October 29, 2024

**Re: Response to Technical Comments – SPC Application D07-12-24-0087; 2900 Brian Coburn Blvd./119 Ryan Reynolds Way**

7.5 m TREE PLANTING SET-BACK

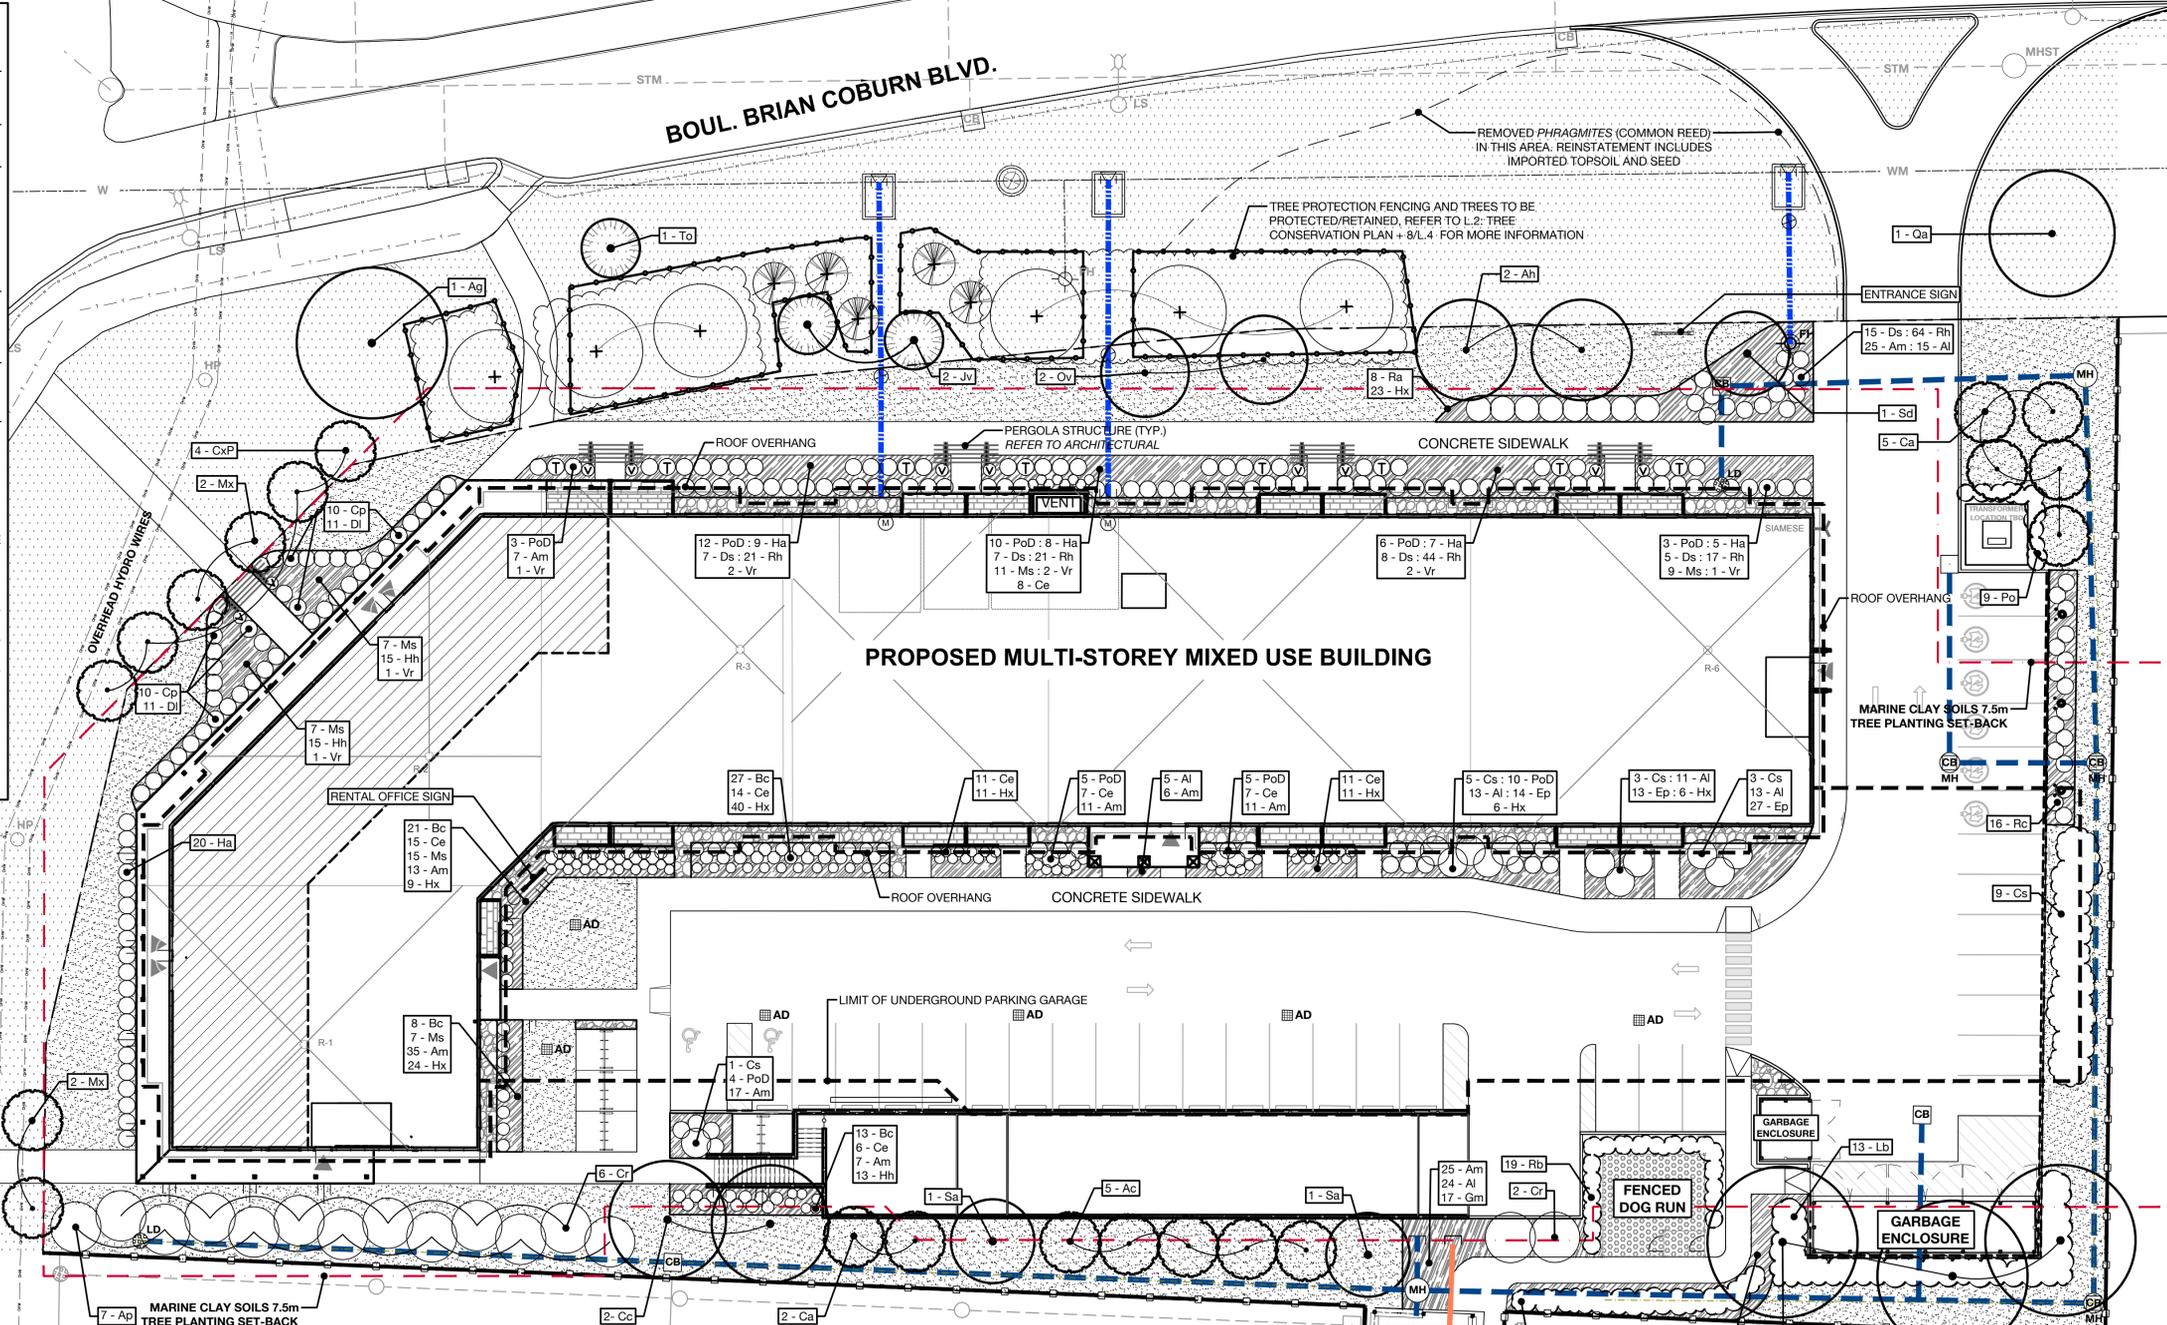
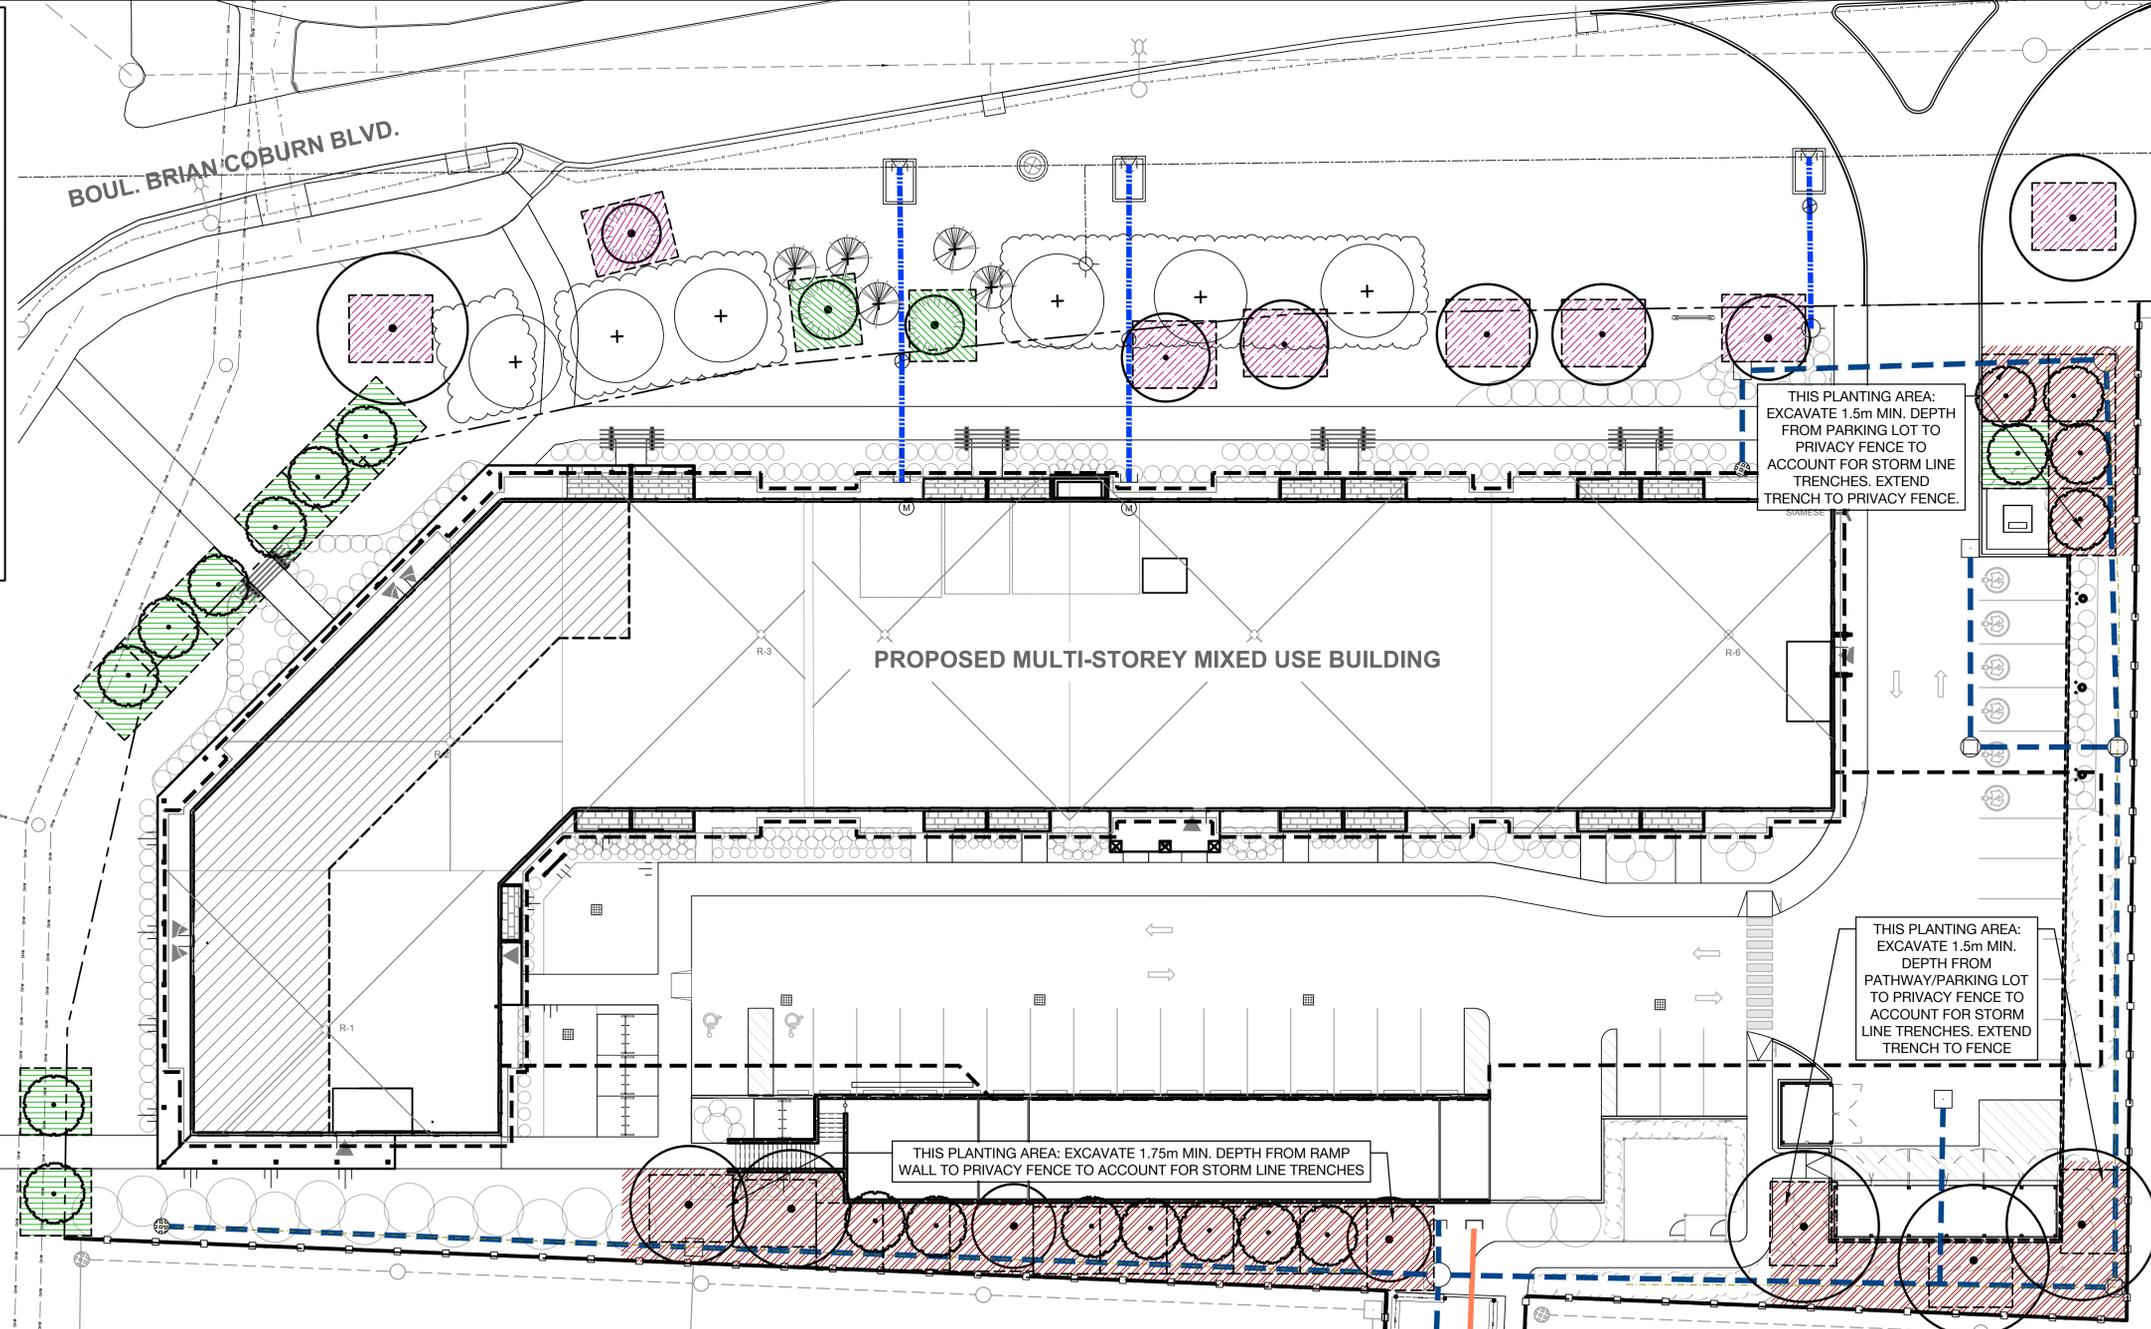
20. Label the distance of the geotechnical setback from the building as the Geotechnical Report indicates it must be 7.5m.	There is a setback line and it is listed in the legend.

21. The Geotechnical Report indicates a 7.5m setback from the building to small/medium trees is required on this site. The Landscape Plan states the setback requirement is 4.5m for small/medium trees. Some existing and proposed trees appear to be under 5m from the building edge based on comparison with the Architectural Plans as the scale on the LP is not accurate. Was the building designed to provide a reduced setback from what was originally required by? Has the geotechnical engineering consultant approved this? If so, please update the Geotechnical Report and Landscape Plan to address this change. Update the LP to reflect the appropriate setback requirements and note the plan was prepared in conjunction of the most up to date	The affected notes have been updated on the landscape plan to reflect the most recent geotechnical report from March, 2023. There are no trees within the 7.5m setback.

DRAWING #: **L.2** REV #:

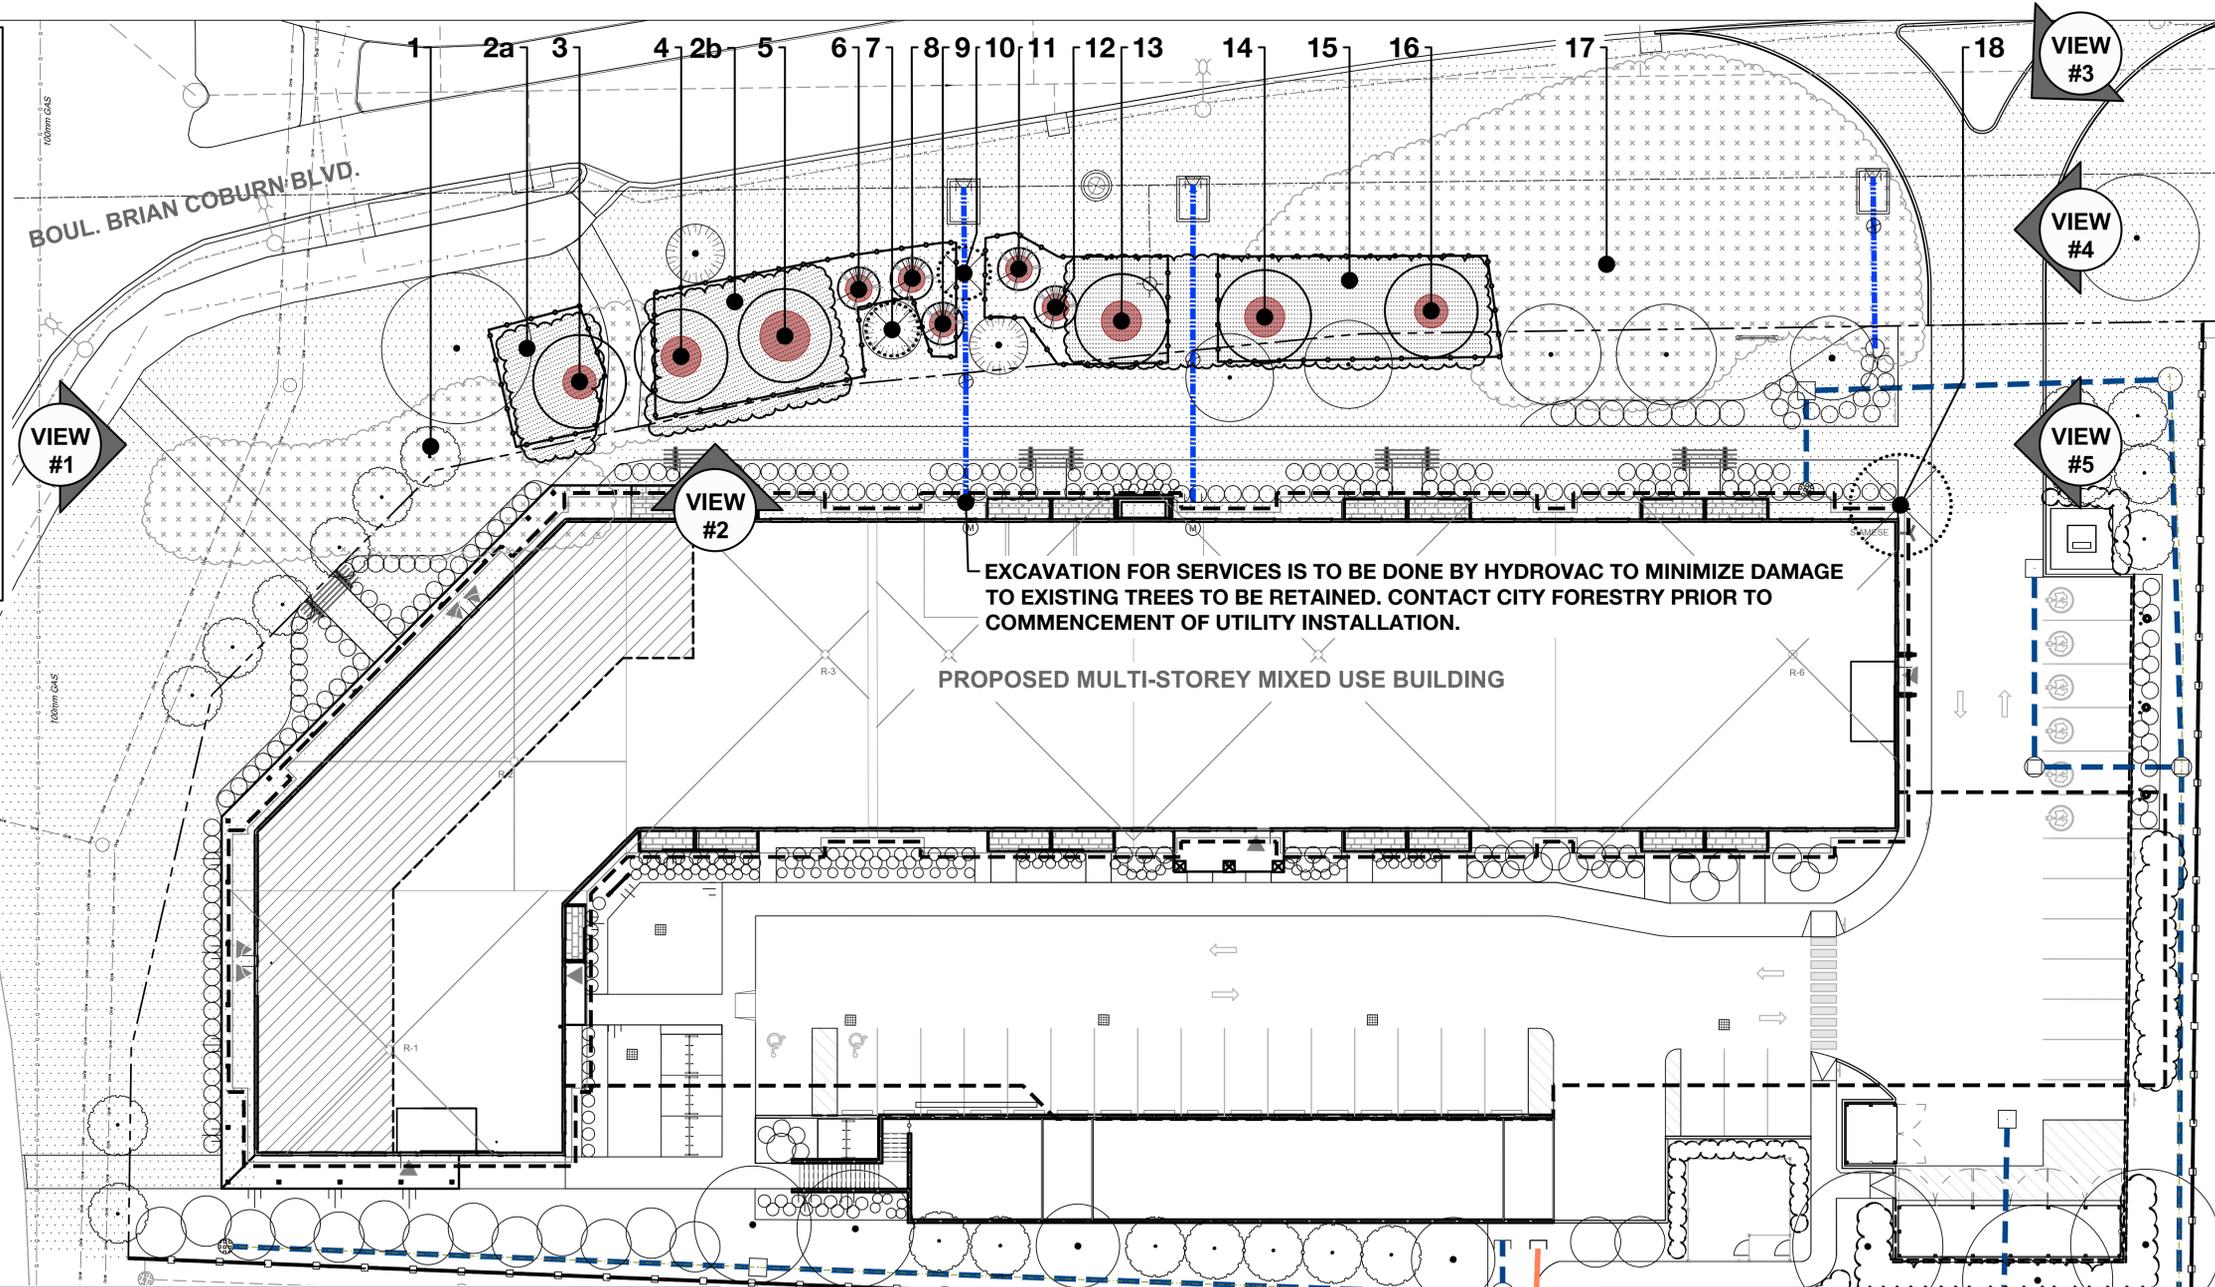
19. The LP still does not demonstrate the space allocated for adequate soil volumes for each tree planted by including on the plan a marked off horizontal area of soil and expected depth of uncompacted soil to calculate volume. A common practice is using a dimensioned shape, often a square, to show at least the minimum soil volume requirement is being provided for the size of tree proposed.	There has been a new sheet added to the landscape plans package. Refer to L.2 - Soil Volumes Plan.
